Consultation Response from KC,
Trees

2025/90457 The Croft, 150, Denby Lane, Upper Denby, Huddersfield, HD8 8UN

Demolition of existing buildings and erection of two residential dwellings (Use Class C3) with associated parking and landscaping (within a Conservation Area)

Date Responded: 21/03/2025

Appendix 5:
Tree Constraints Plan
150 Denby Lane, Upper Denby, HD8 8UN
Ref: AWA6411

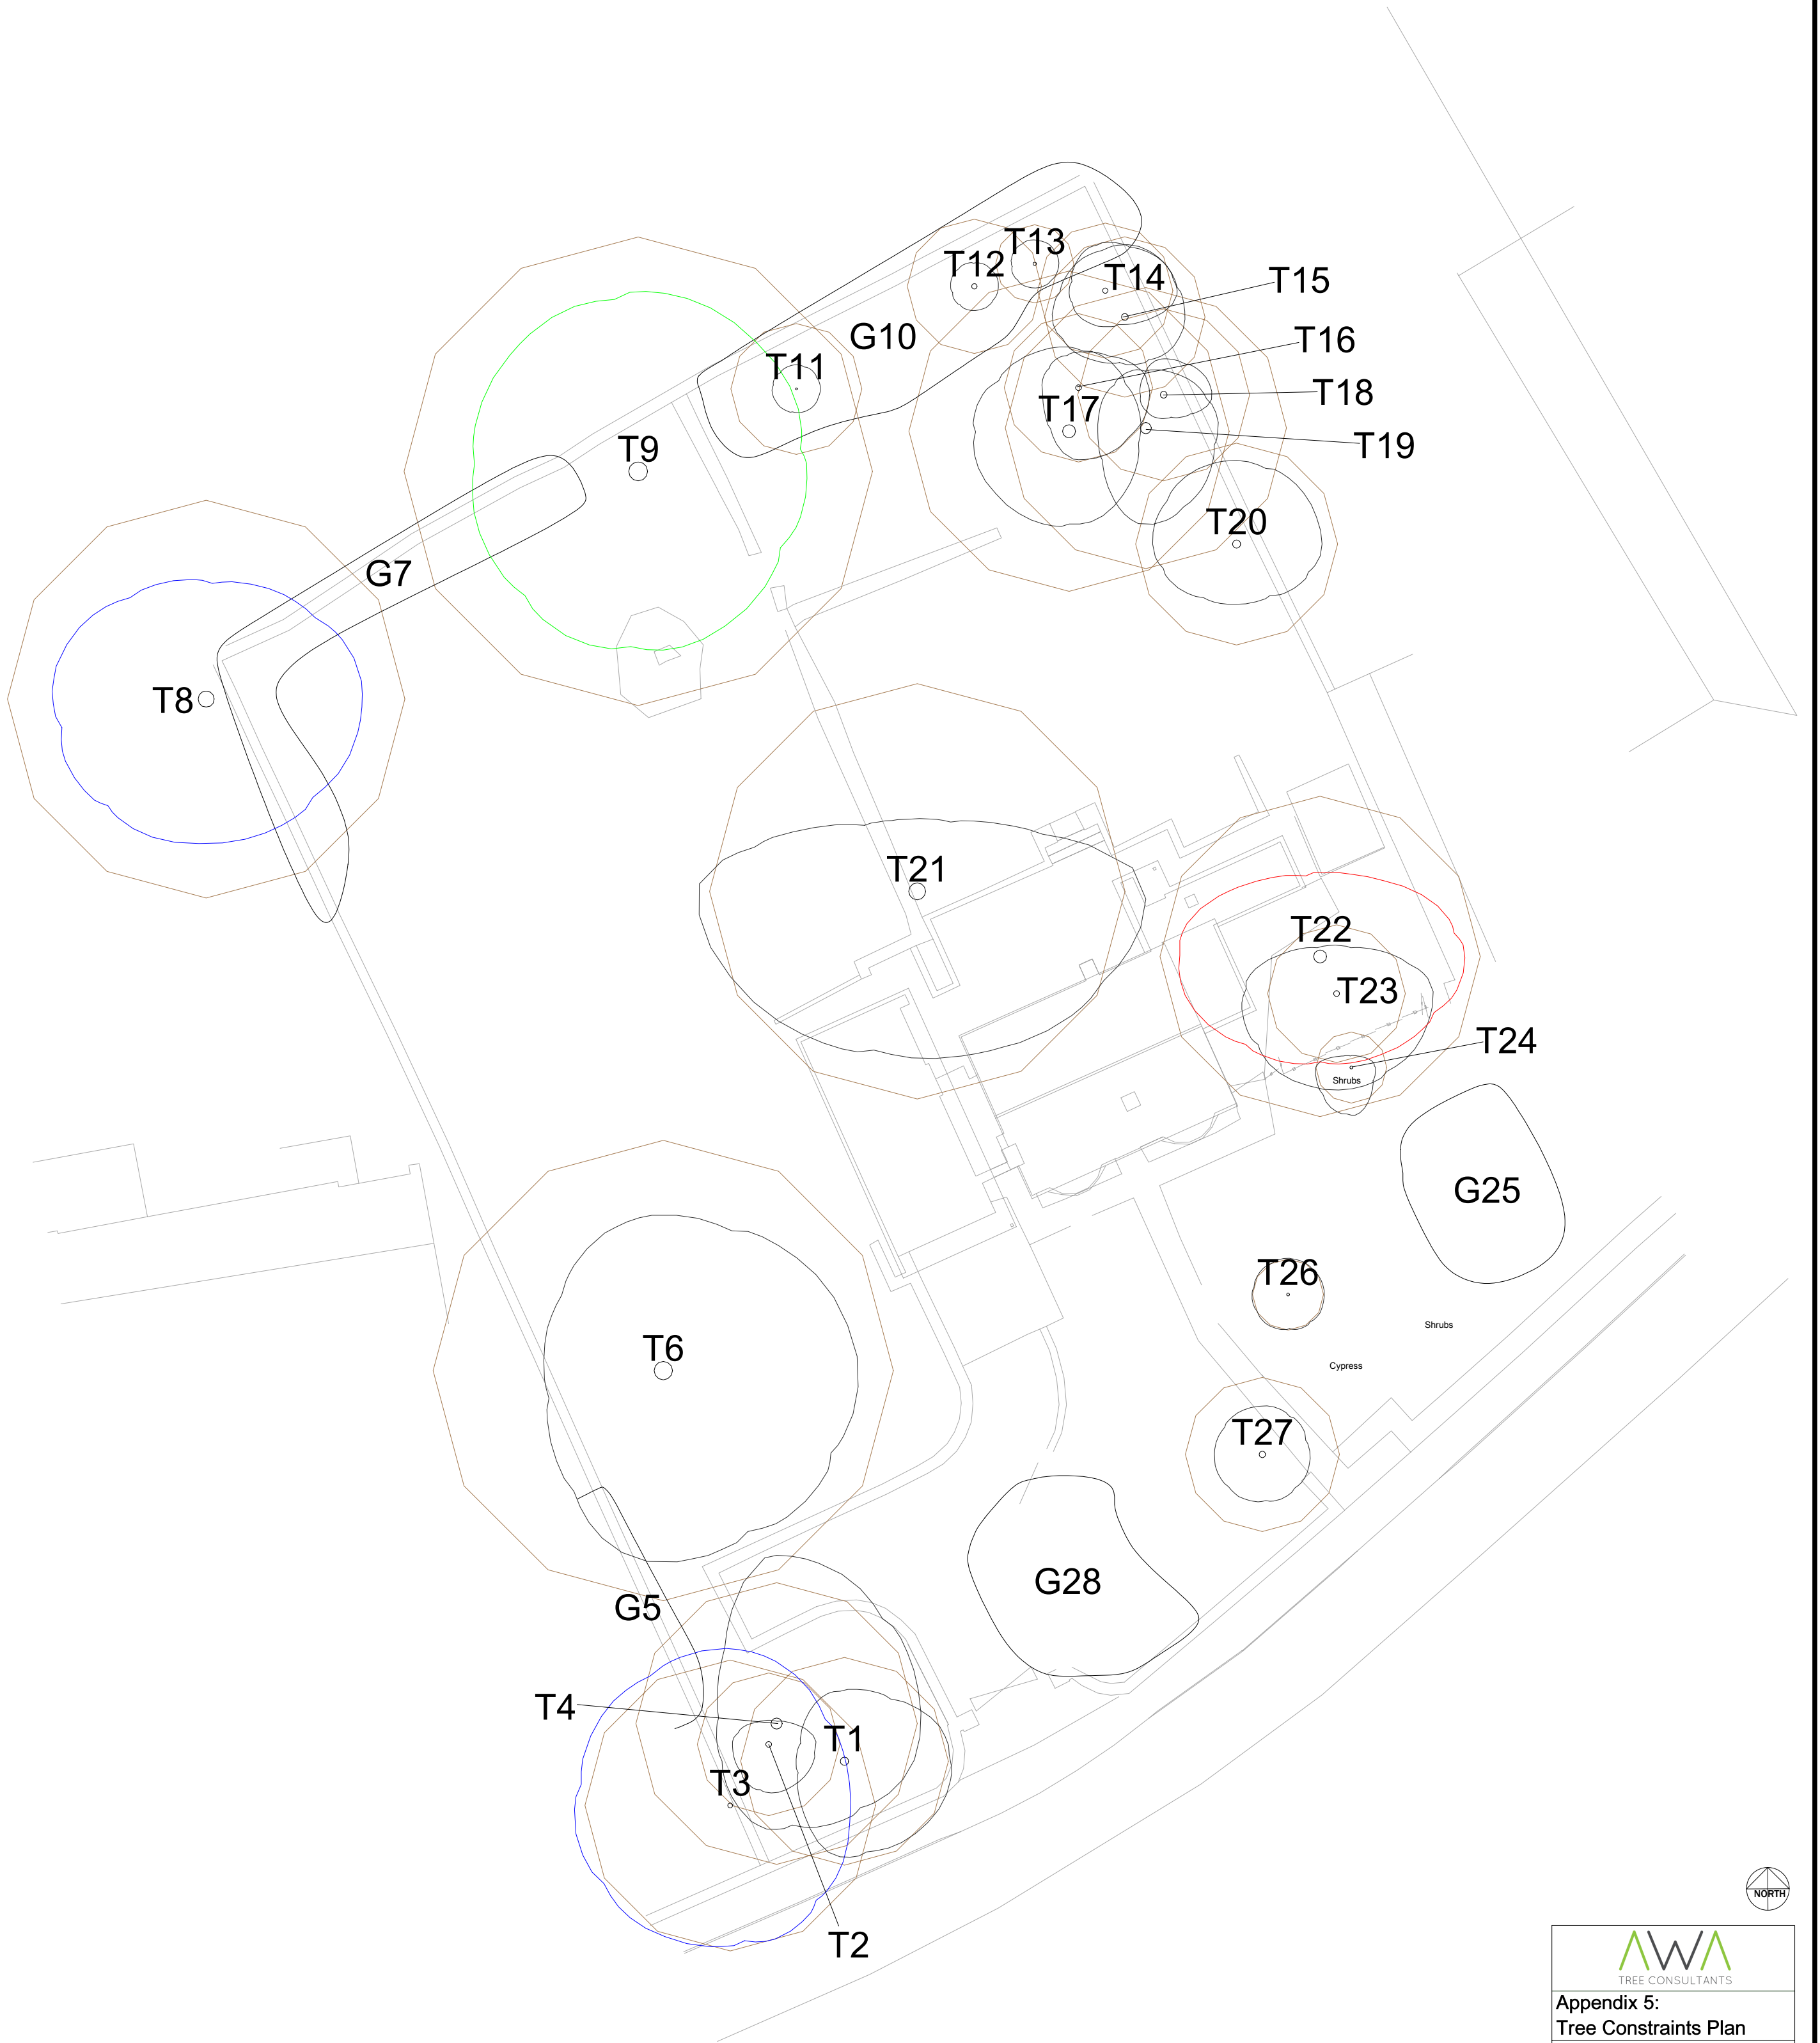
To facilitate the proposals 7 individual trees and 1 group would require removal. All these trees are Category C, of low arboricultural value. These losses would be acceptable on the condition of replacement planting agreed with Kirklees Council.

The Category A tree T9 is located on the Northern boundary and is a tree of significant arboricultural value. The proposed larger building is positioned close to edge of the canopy of T9 and is encroaching within the RPA. This proximity would place pruning pressure on the tree which could spoil its visual amenity value, whilst also being detrimental to the long-term health and retention of the tree.

Appendix 6:
Tree Impacts Plan

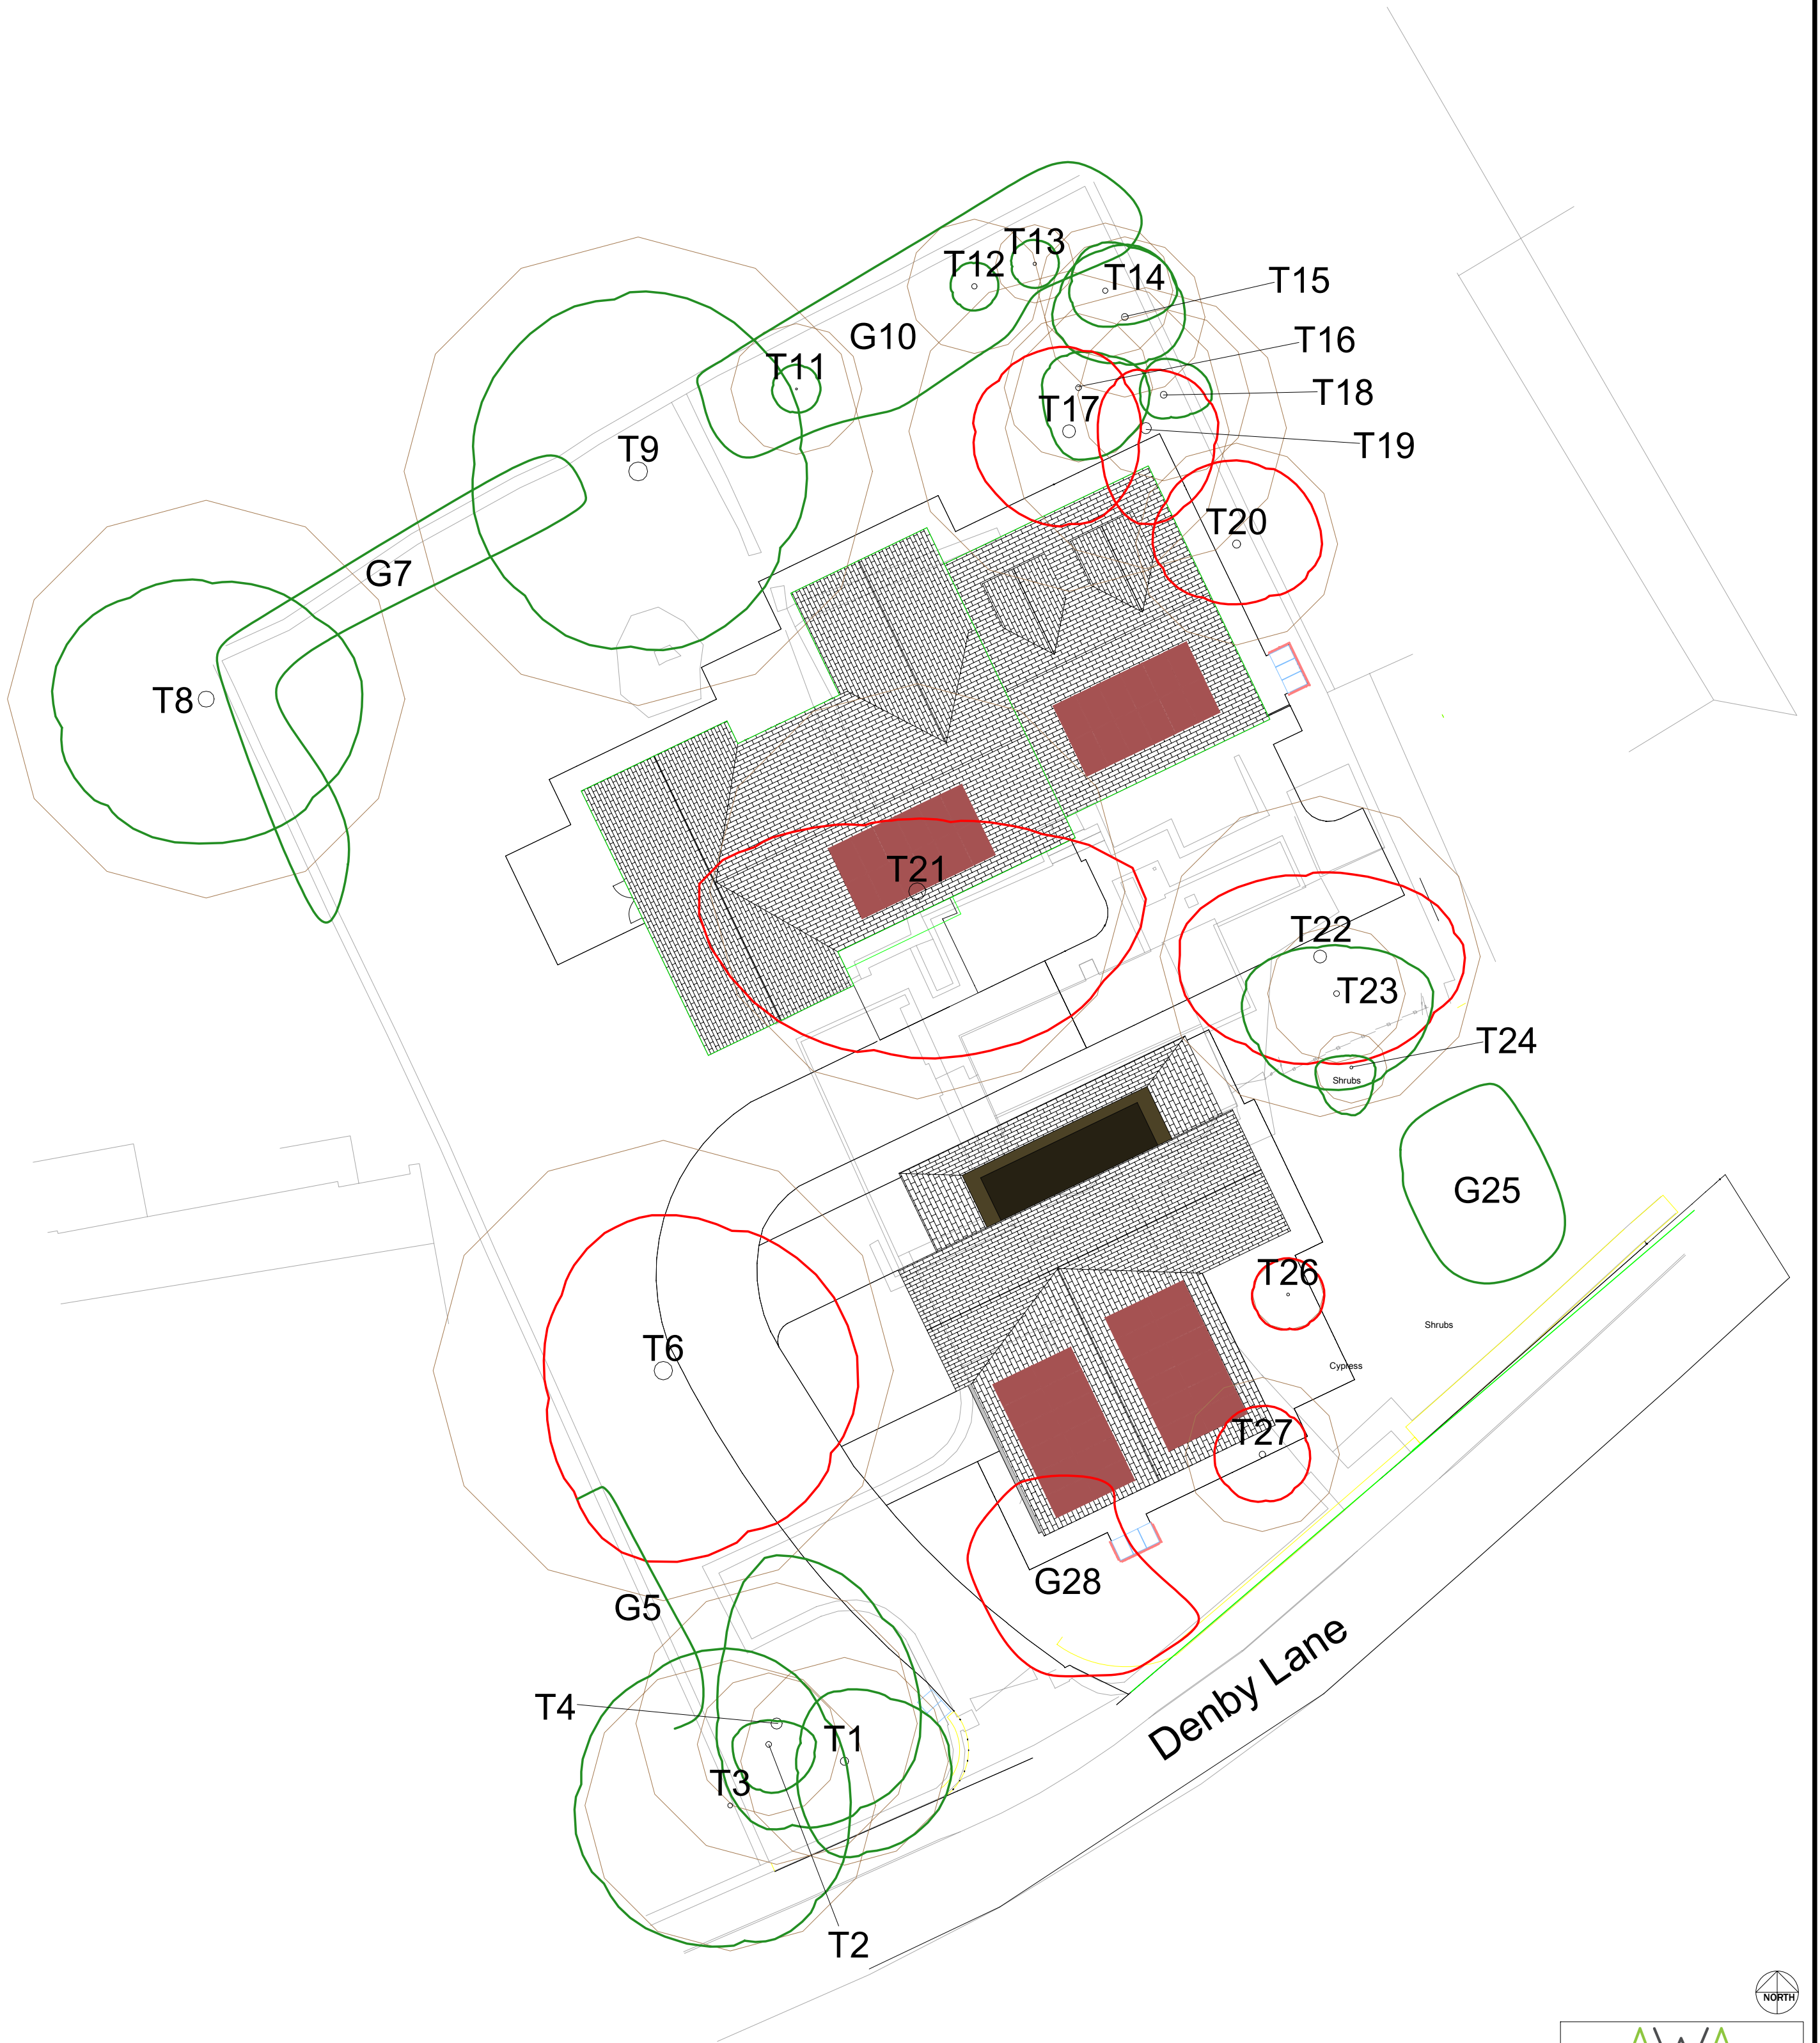
The new access road minimally encroaches the edge of the RPAs of T1 and T4, again this would be considered acceptable with approved tree protective measures in place including access facilitation pruning to prevent tear-outs during the works.

From the future resident's point of view, having an 18m tall, mature tree this close to their house would likely cause issues such as leaves in the guttering, shedding branches close to the house, shading of the garden, worries about the tree failing onto the building during storms and high winds ect.

There is an objection from an arboricultural perspective. The proposal conflicts with adopted Kirklees local plan policy 33 and 24 (i) due to the proximity of the proposed to the Category A tree T9, which both directly and indirectly threatens the health of the tree.
